RE: DRB – Project #1009290 – Southwest Mesa/Snow Vista Substation

In response to EPC Conditions of Approval at the July 12, 2012 hearing, PNM's responses are below.

**Project# 1009290 \***  
12EPC-40030 Site Development Plan for  
Building Permit

DATE: August 31, 2012  
TO: Jack Cloud, DRB Chair  
FROM: Catalina Lehner, Senior Planner *cel*  
RE: Project #1009290, PNM SW/Snow Vista Substation  
Site Development Plan for Building Permit

DR: DK	TR:	DATE: 7/30/12
CKD:	OK:	SCALE: 1"=10'-0"
APP:	ACAD FILE: USS8201	SHEET 6 OF 7
REV. NO.

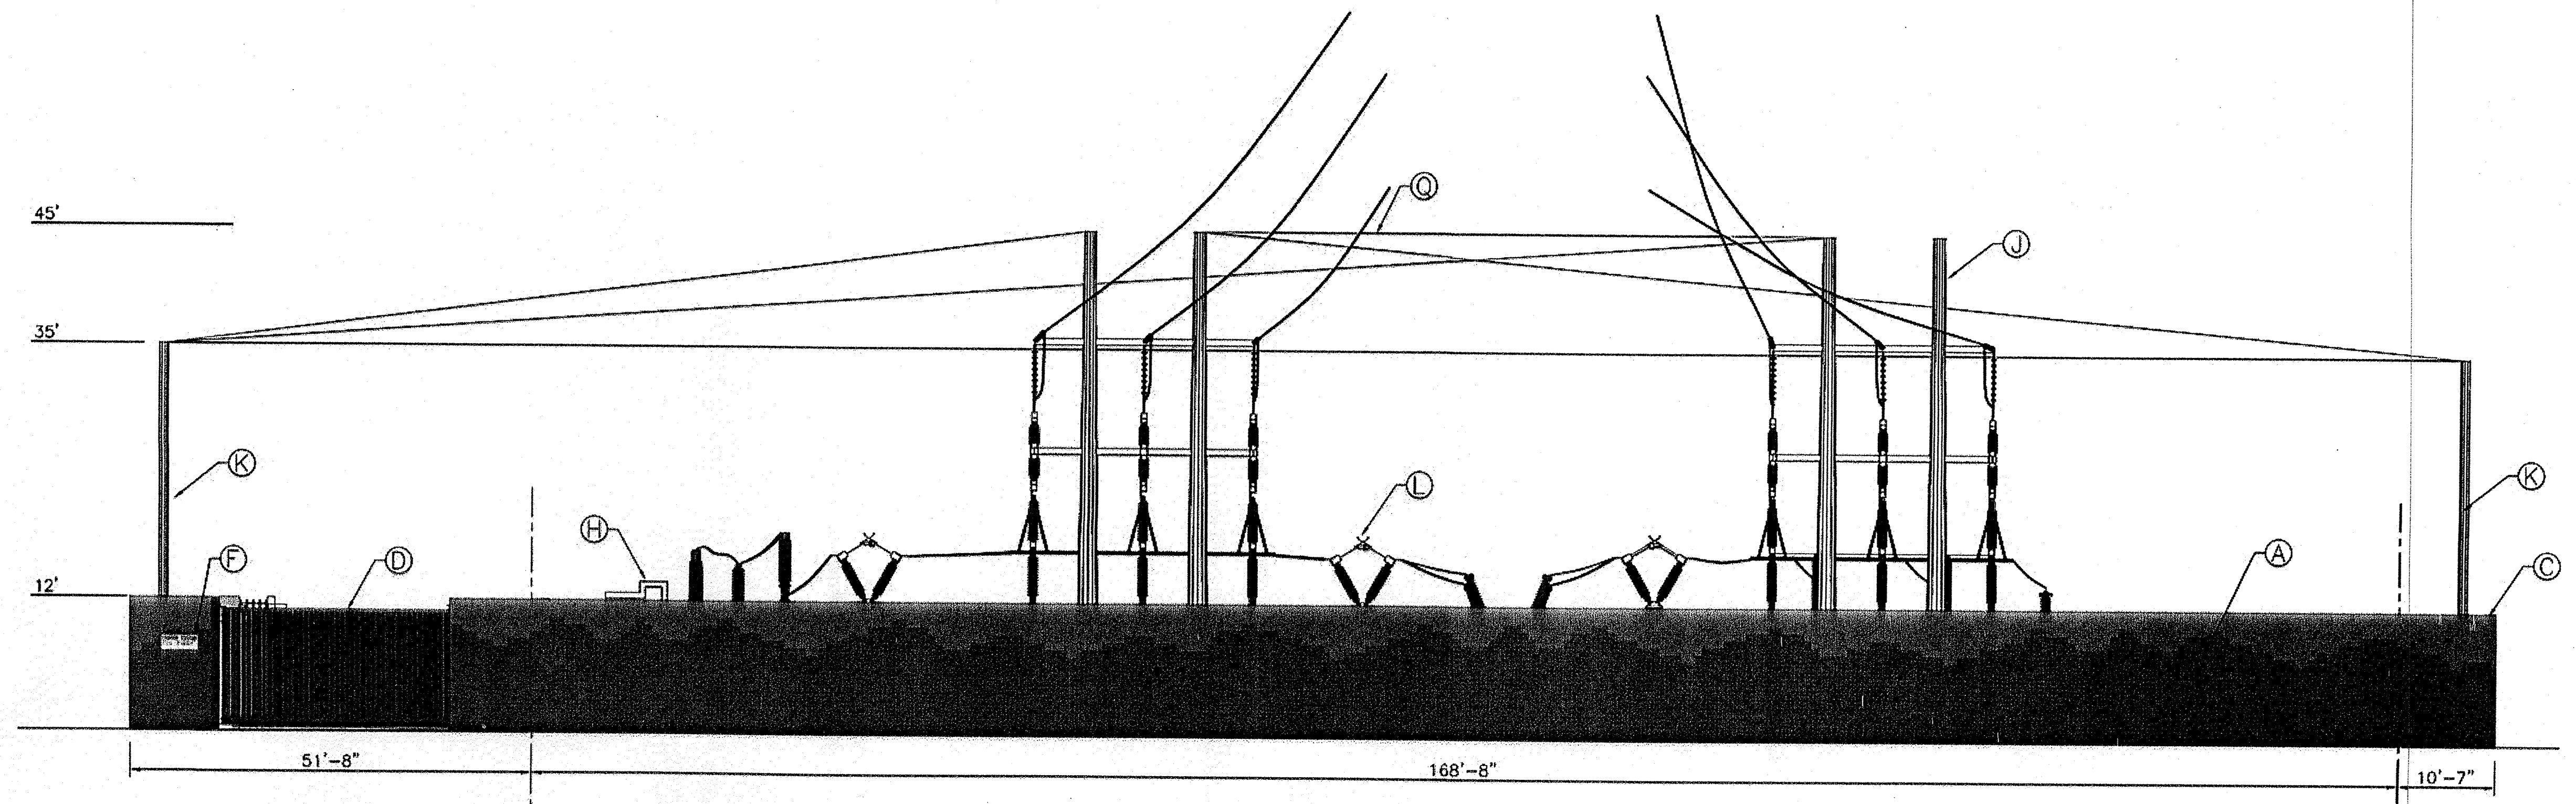
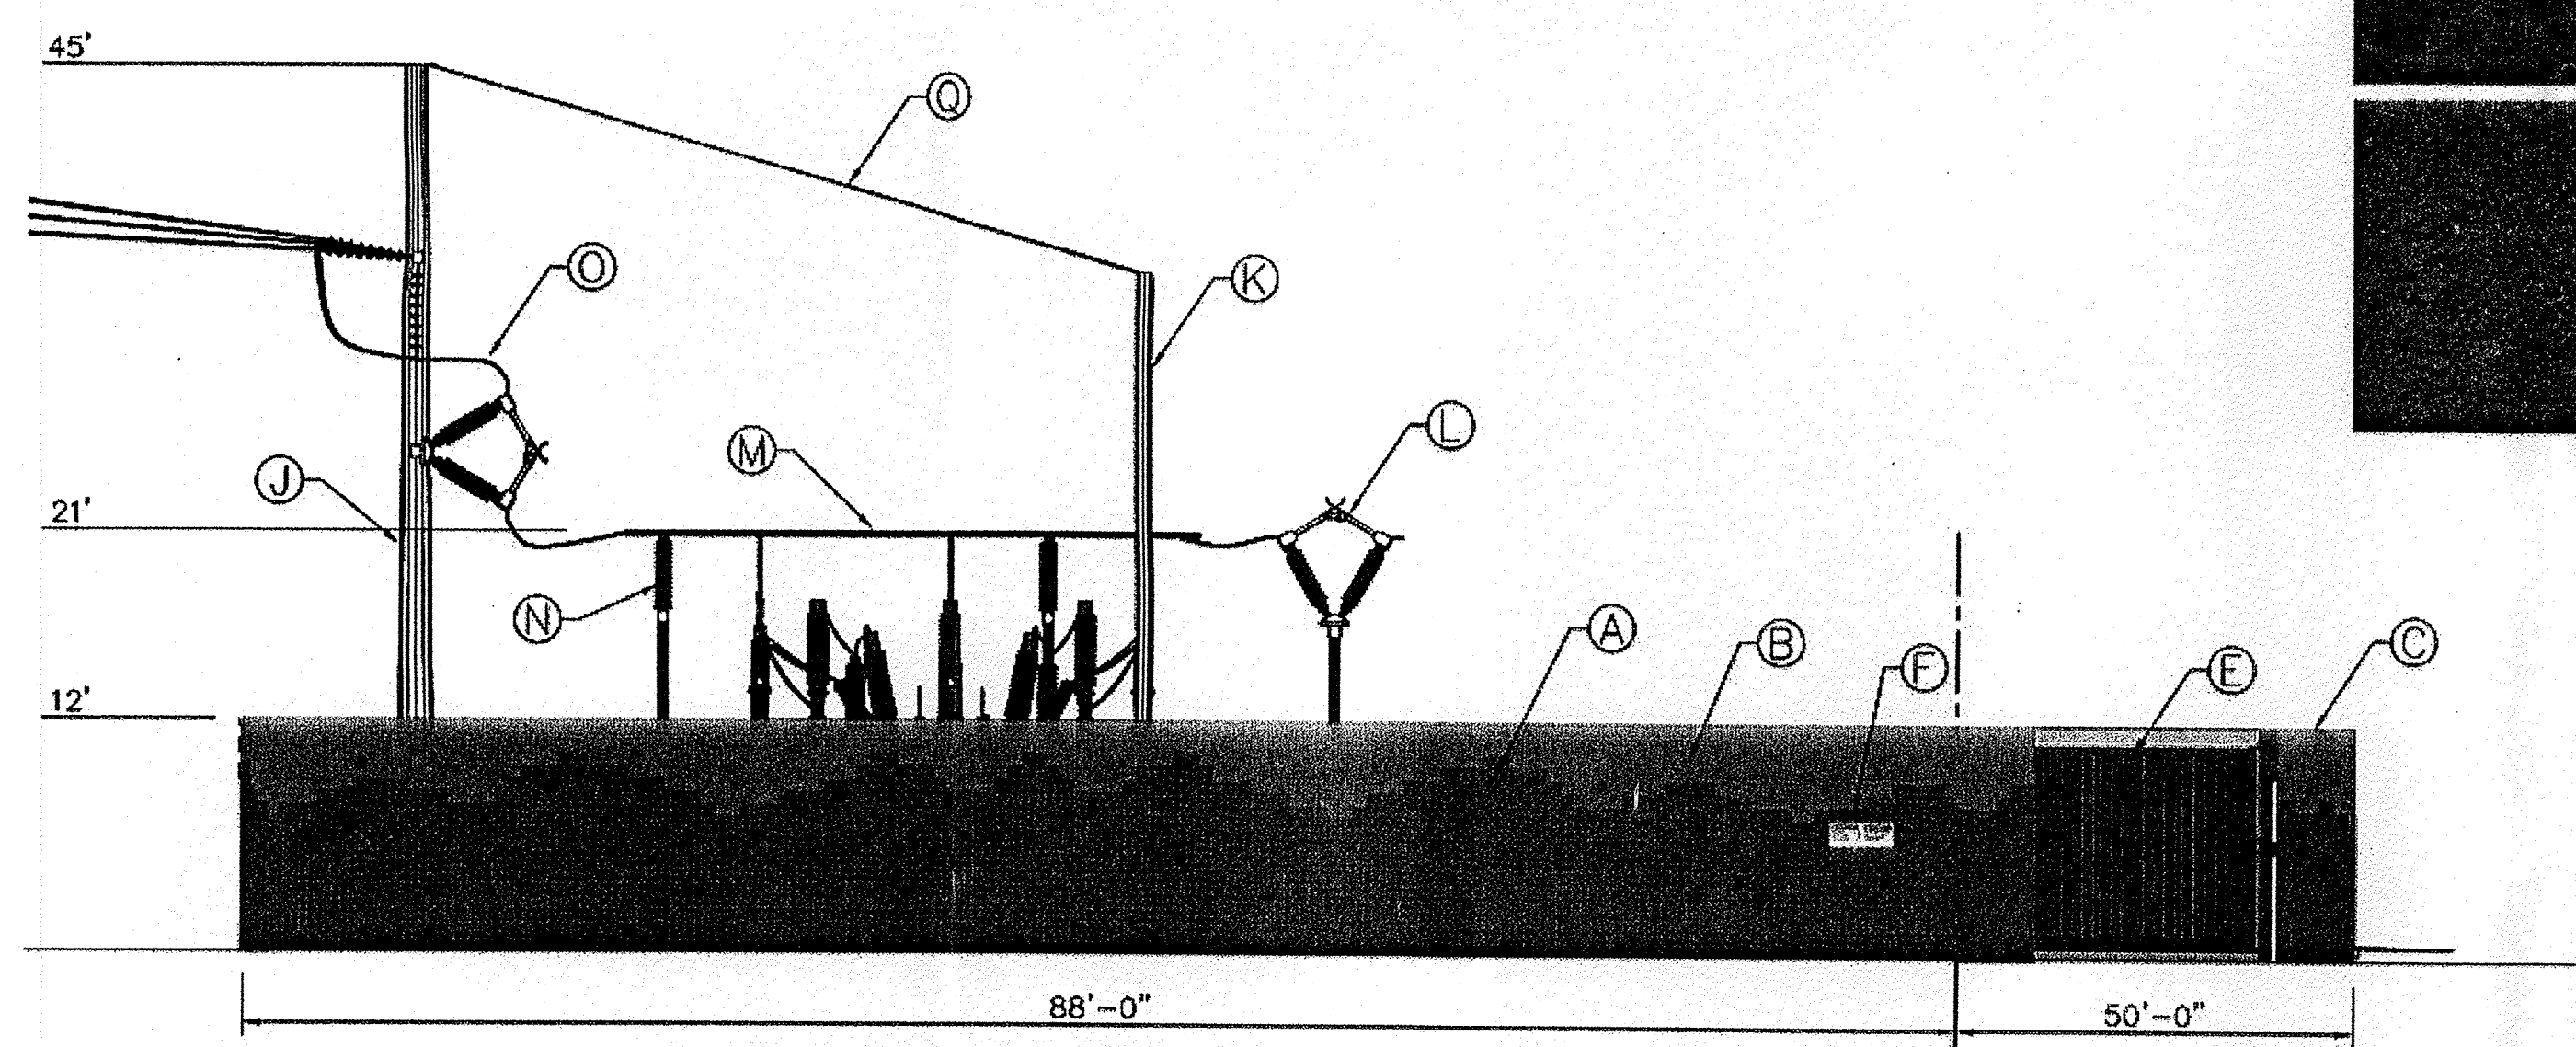
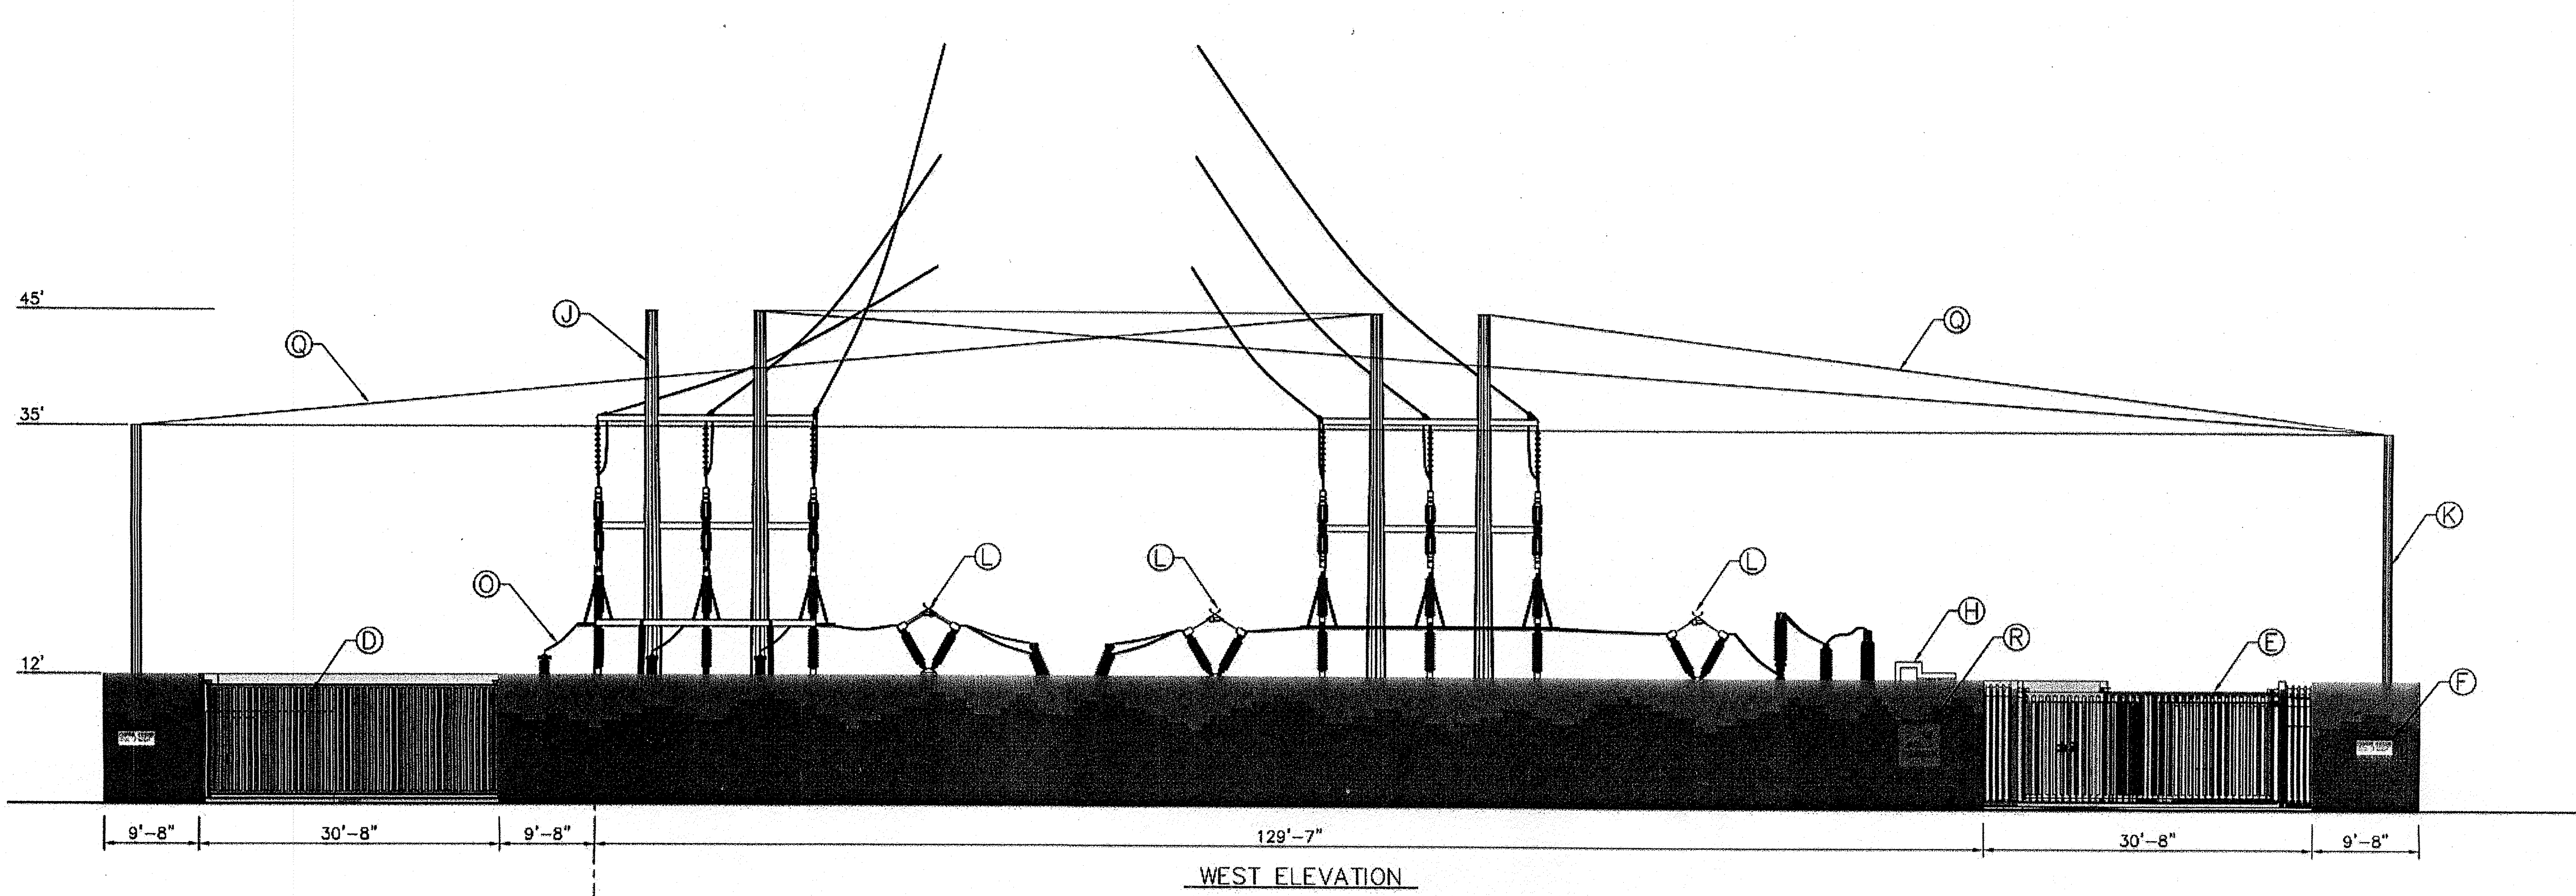
- A. *The continuous wall cap shall provide a minimum 2 inches from the public side of the wall [§14-16-3-19(B)(2)(b), the façade subsection].*

- B. *At least one feature from §14-16-3-19(B)(2)(a), the layout subsection, is required for each wall.*

B. *Specify if "Brevity Brown" is light, medium or dark.*

PNM Response: On Sheet 6 and Sheet 7, the following note has been added:  
"Continuous overhang cap will project two inches from the wall."

PNM Response: The substation wall contains variation in the façade surface and in the texture by complying with §14-16-3-19(B)(2)(a), 1. d., in which the wall design incorporates a two-tone multi-textured block mountain image as a decorative feature in the wall design; therefore, the wall design meets the requirement of §14-16-3-19(B)(2)(a). Vertical pilasters with a projection of 2 inches will be placed at intervals of 20 feet as noted on sheet 6 and 7.

PNM Response: Medium brown has been added to Items D and E on Sheet 6 and 7.
